From: Planning
Subject: FW: FW: 3/2021/0172 - Kings Arms 144 Bawdlands Clitheroe BB7 2LA
Attachments: Parking layout.pdf

Subject: 3/2021/0172 - Kings Arms 144 Bawdlands Clitheroe BB7 2LA

With respect to the proposed change of use of first floor from manager's flat to offices, whilst I would raise no objection to the principle of the development proposal I must ensure that the proposal would not be detrimental to highway users.

PROPOSED FIRST FLOOR PLAN
SCALE 1:100

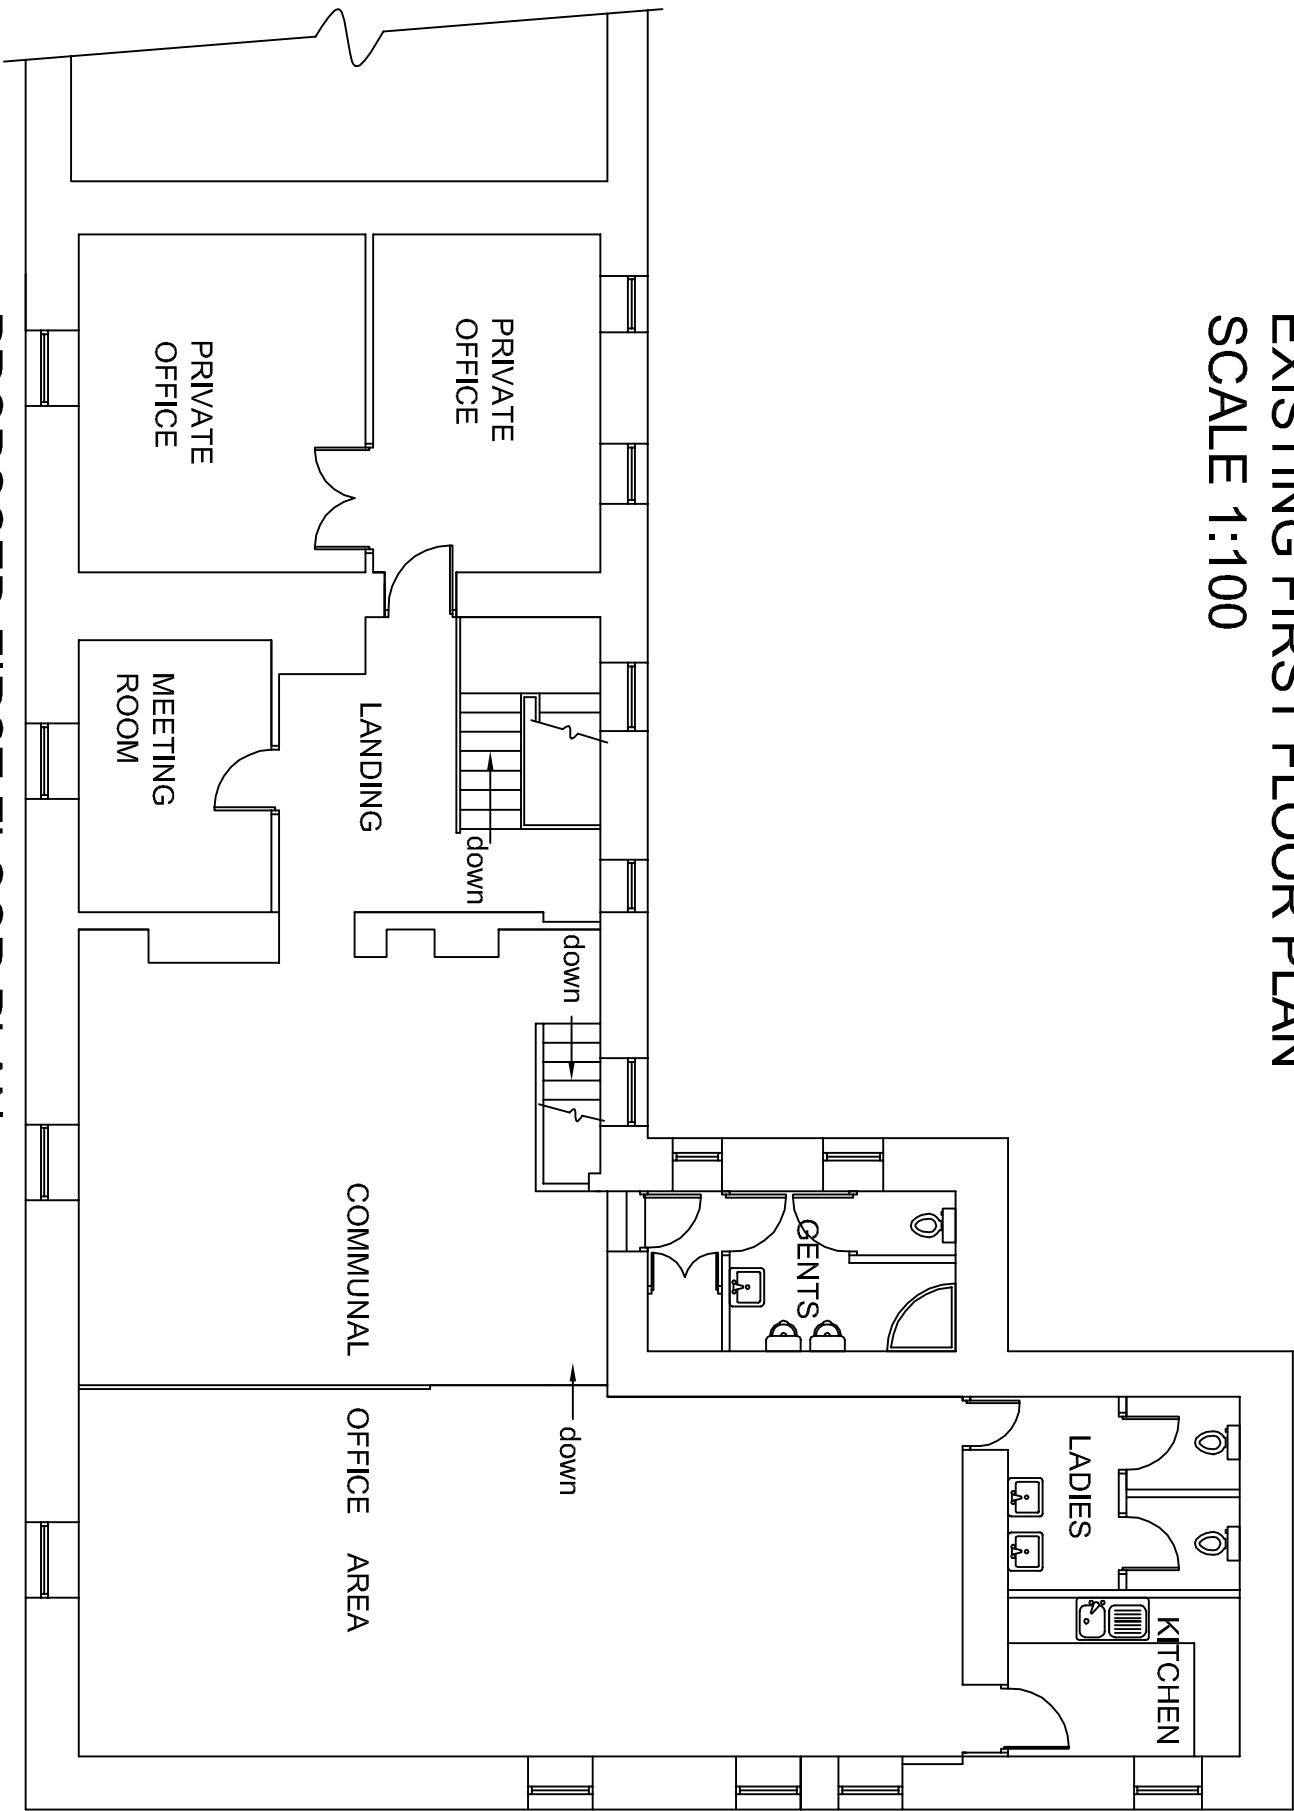
The proposal will result in a change of use to the first floor of the building from a flat to offices, although no details of how the proposed change of use will function. I would therefore need to understand how many office workers are likely to work from the proposed offices, will the offices be set for an individual company or provide office space for individuals on a rental basis? Also, how will the offices be accessed.

The offices will be for the applicant's own company currently located in Clitheroe Business Centre. The company employs 8 people. At no time will the offices be let as individual units. I have attached a parking plan showing details of the spaces available. The office use will operate during the day, with the pub operating in the evening.
